CITY OF ALBUQUERQUE

April 18, 2023

Re: Tidal Wave Auto Spa
2601 2nd St. NW
Traffic Circulation Layout
Architect's Stamp 03-23-23 (H14-D071)

AS101

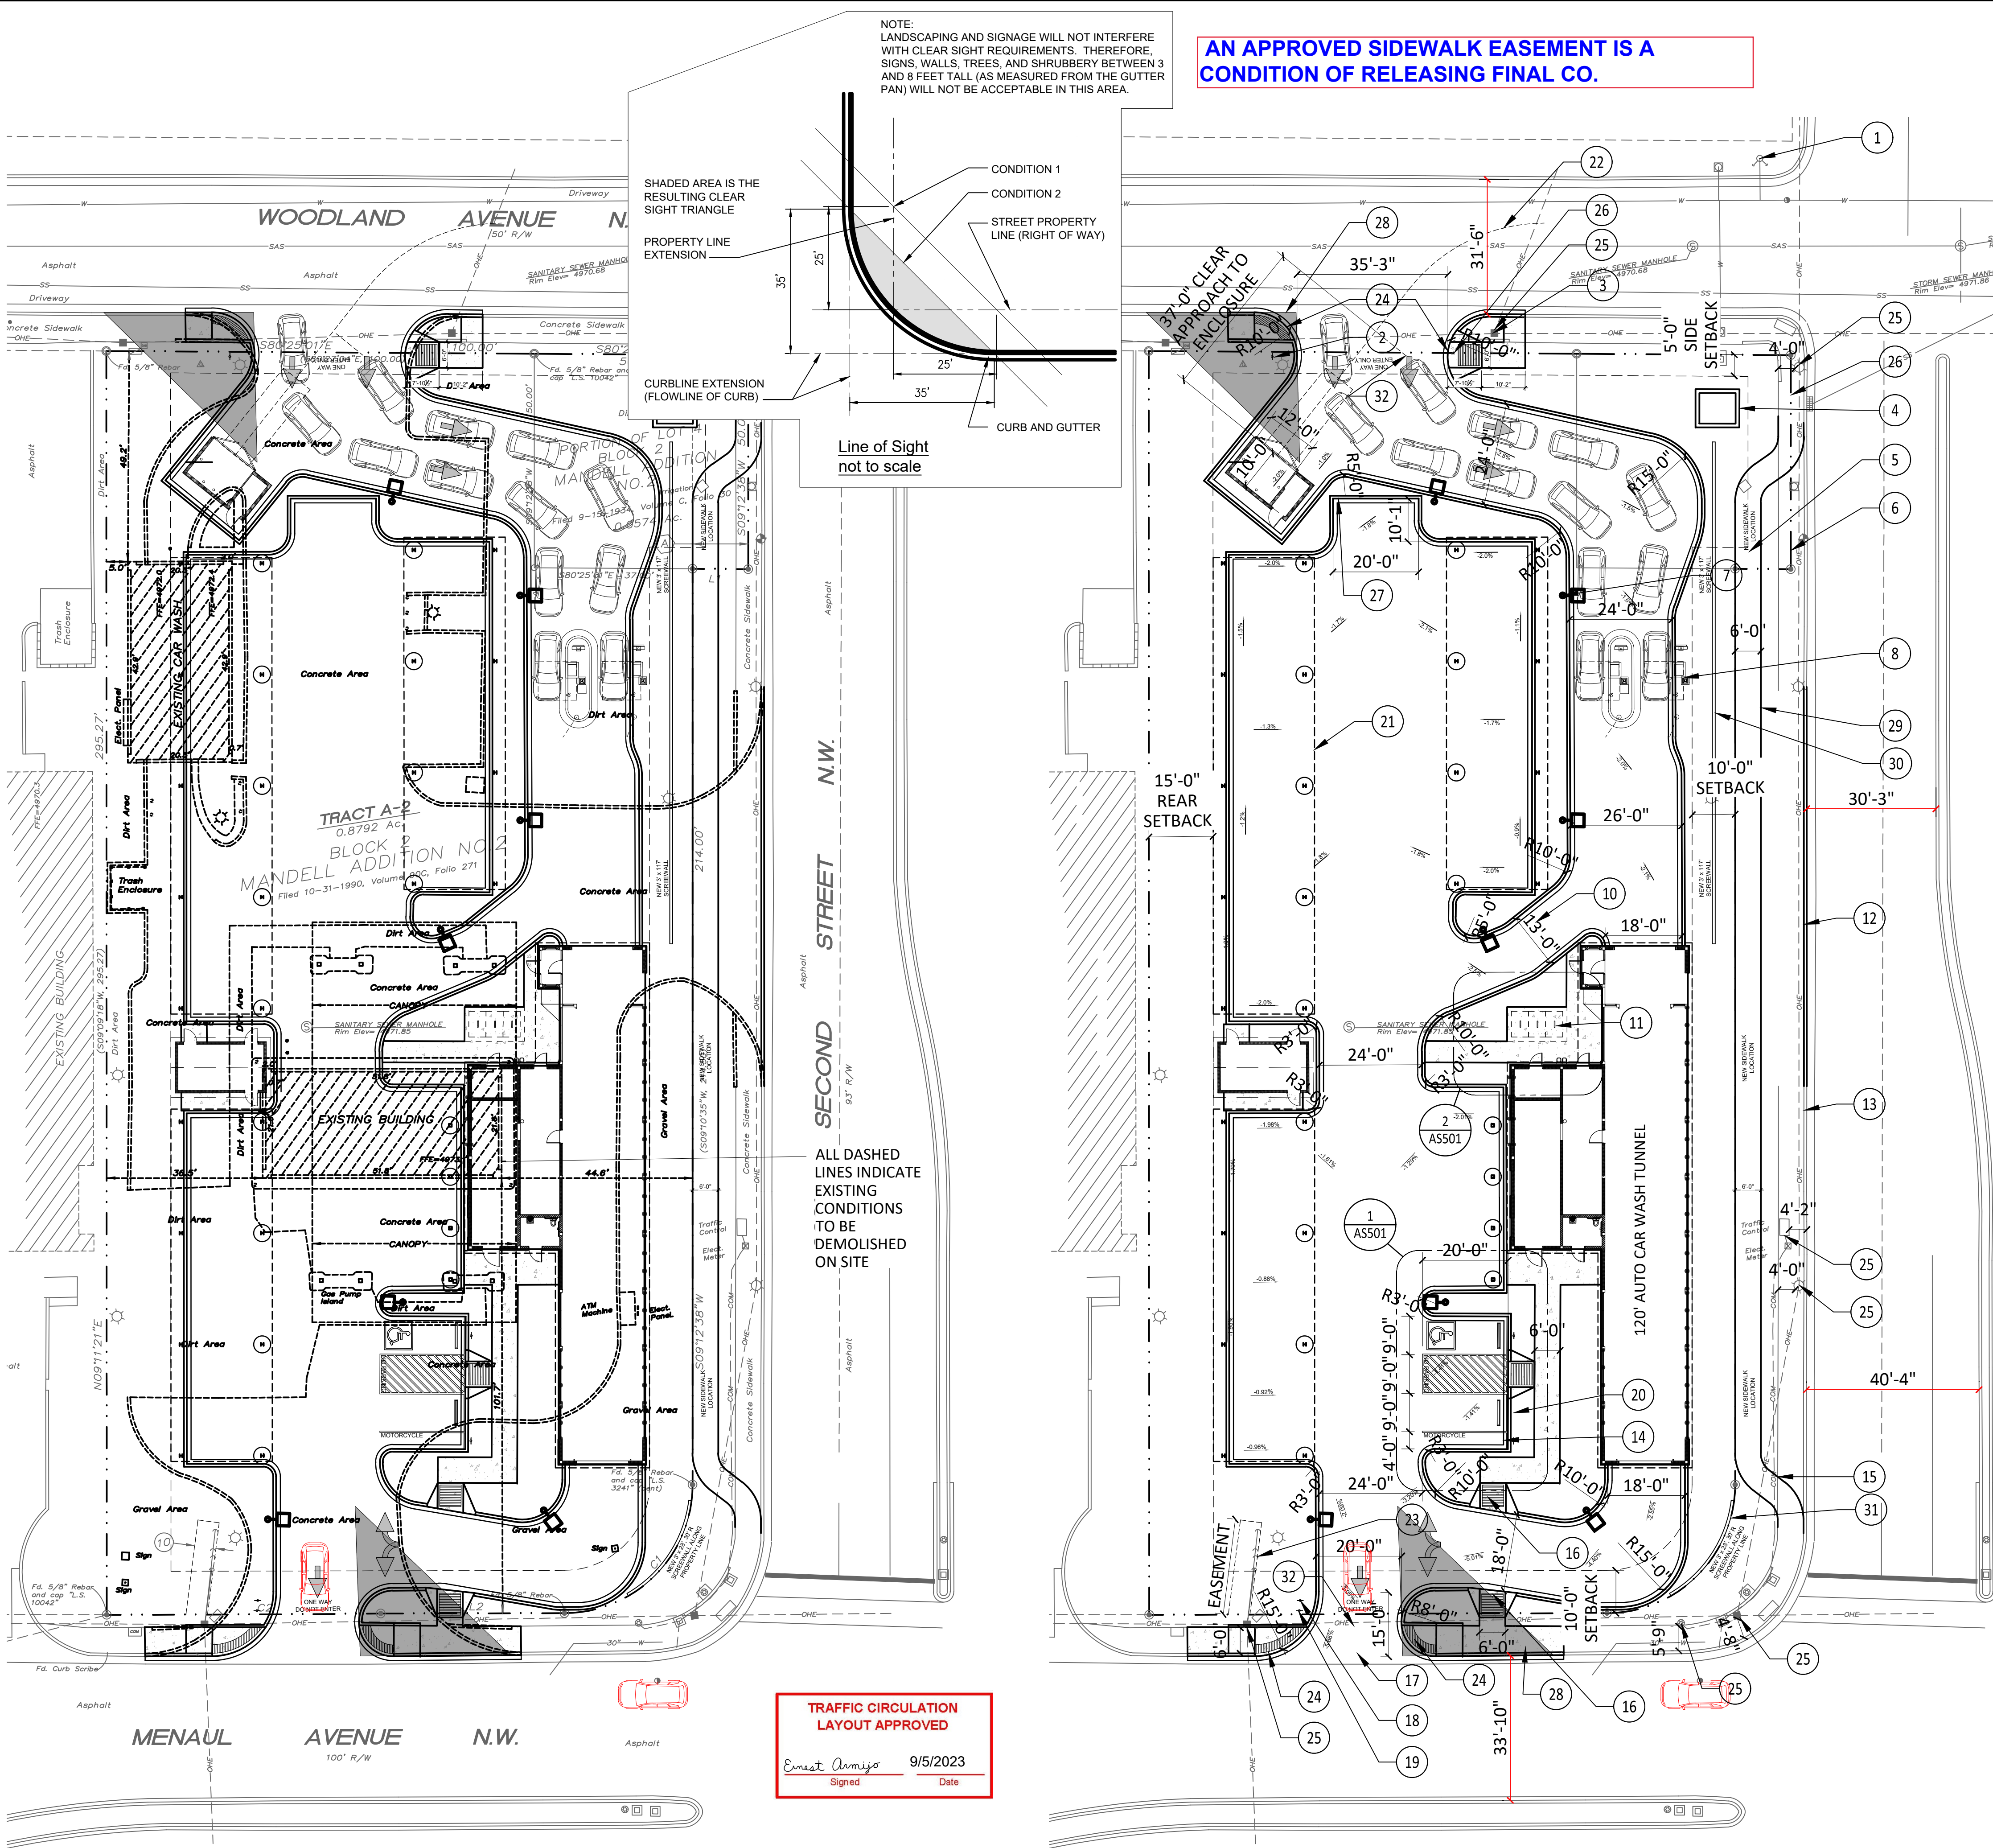
1. Identify all existing access easements and rights of way width dimensions.
2. ADA curb ramps at both site accesses must be updated to current standards and have truncated domes installed.
3. Key not 16: please provide details for all proposed interior ADA ramps.
4. Key note 3: please provide extending sidewalk details. A minimum 4-foot wide pedestrian path should be shown around of the pole; show this dimension on the site plan to ensure that a minimum 4-foot wide path is obtained. Also, show the clear four foot around each obstacle on the public sidewalk off 2nd St. and at the corner of 2nd St. and Menaul Blvd. see attached.
5. Key note 3: if you are going to extend the sidewalk into the property, so, a sidewalk easement needs to be provided.
6. Since the property line located in the middle of the sidewalk off 2nd St. Please provide a sidewalk easement for this portion.

7. For sidewalk easement please contact Carrie Mouck at 505.924.3996 e camouck@cabq.gov
8. Please clearly show this dimension, and note that A minimum 5 ft. keyway is required for dead-end parking aisles.

9. All bicycle racks shall be designed according to the following guidelines:
 - a. The rack shall be a minimum 30 inches tall and 18 inches wide.
 - b. The bicycle frame shall be supported horizontally at two or more places. Comb/toaster racks are not allowed.

10. Bicycle racks shall be sturdy and anchored to a concrete pad.
11. A 1-foot clear zone around the bicycle parking stall shall be provided.
12. Bicycle parking spaces shall be at least 6 feet long and 2 feet wide.

13. Provide a copy of Fire Marshal approval.
14. Show the clear sight triangle and add the following note to the plan: "Landscaping and signage will not interfere with clear sight requirements. Therefore, signs, walls, trees, and shrubbery between 3 and 8 feet tall (as measured from the gutter pan) will not be acceptable in the clear sight triangle.

15. Please specify the City Standard Drawing Number when applicable.
16. Unused curb cuts must be replaced with sidewalk and curb & gutter. A build note must be provided referring to the appropriate City Standard drawing.
